Recommendation: Refuse

Applicant: Oxford University Development Ltd

Proposal: Substitution of permeable block paving to parking bay surfacing with a porous bituminous macadam surface (proposed as non-material amendment to 21/03195/F)

DATE: 12 July 2022

**PT2 - ASPHALT CONCRETE (POROUS) PAVEMENT (PERMEABLE, LIGHT VEHICULAR LOADING)**

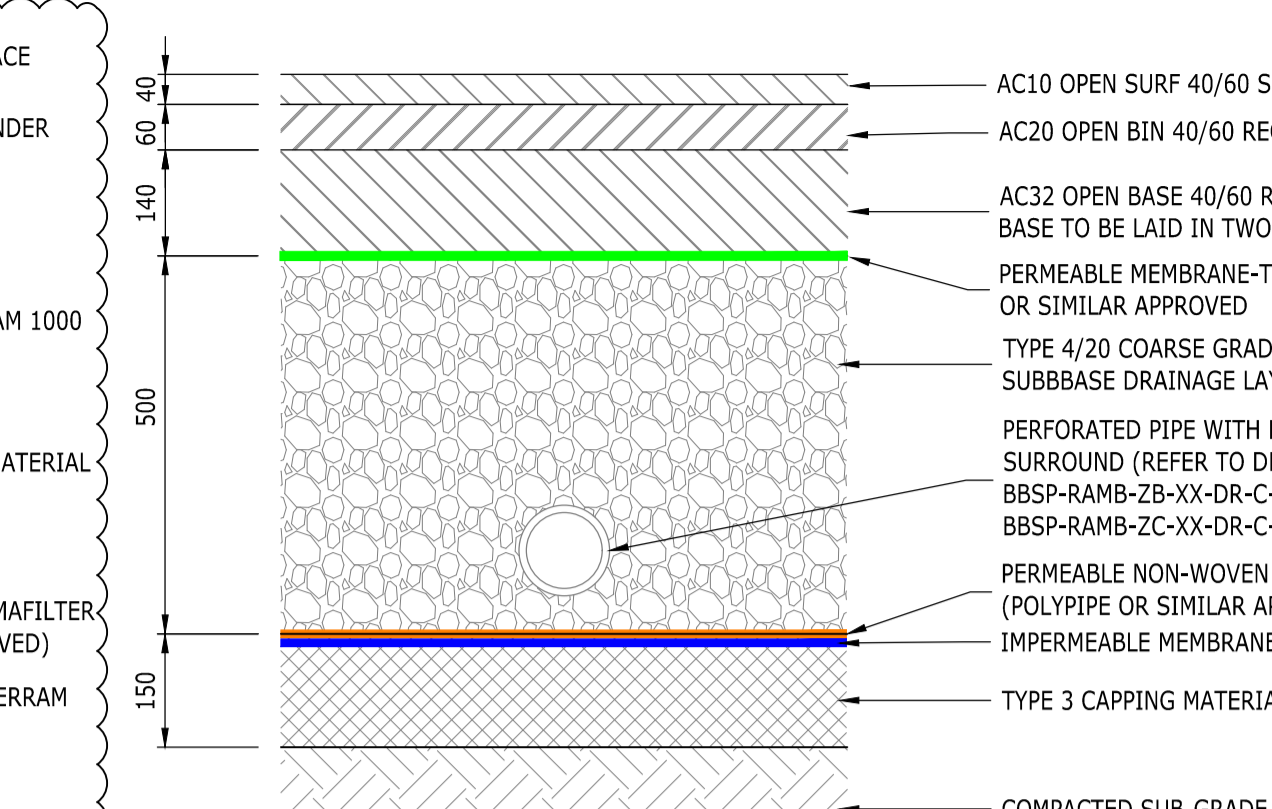
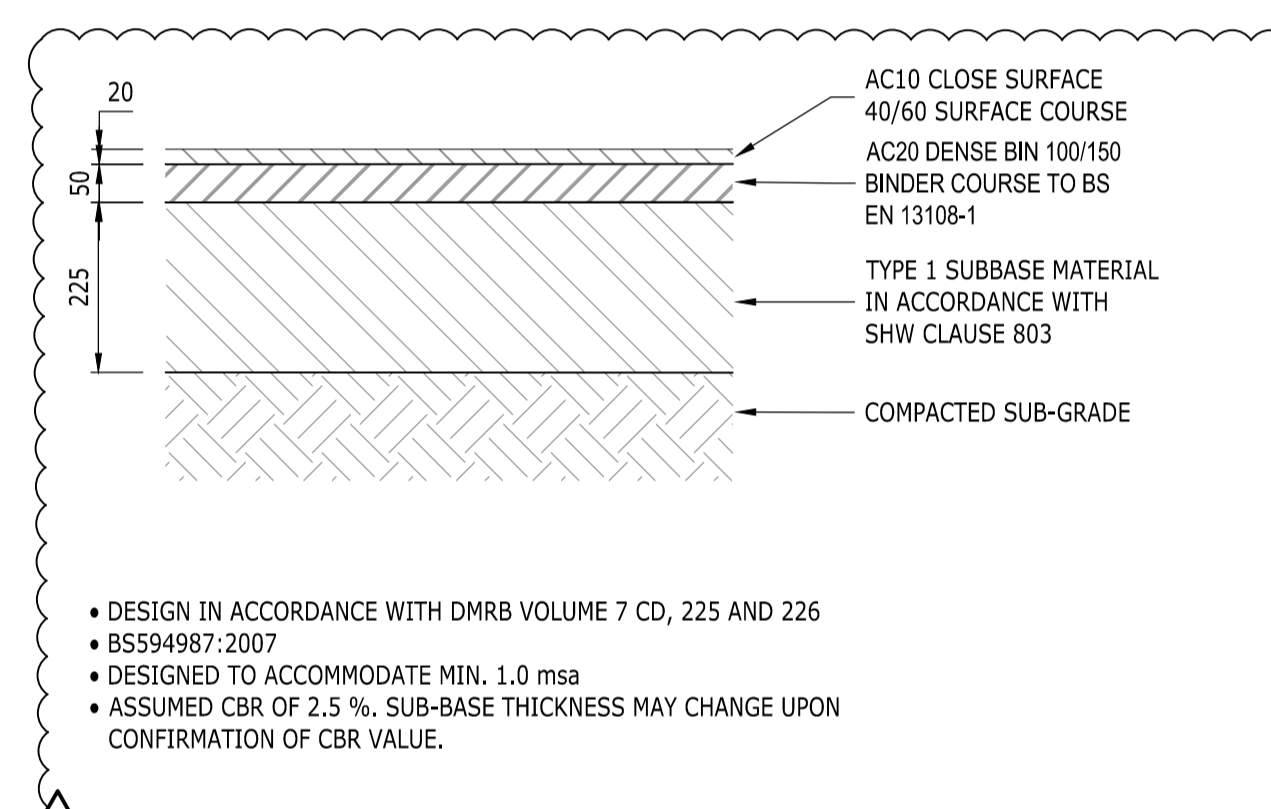
The change from permeable paving to a porous asphalt surface will entail a change in surface water drainage strategy. Therefore revised car-parking drainage details will be required.

The proposals seek to substitute the materials for the surface car park from porous paving with tarmac finish block paving to parking bay with bituminous macadam surface. Given the nature of the material proposed, the change would affect the drainage of the parking surface. It is therefore considered that control should therefore be exercised, and planning permission sought. It is therefore concluded that the application should therefore be resisted.

The proposal is considered to be a material change to the approved scheme because the change in material would impact the drainage of the car park. The application is therefore recommended for refusal.
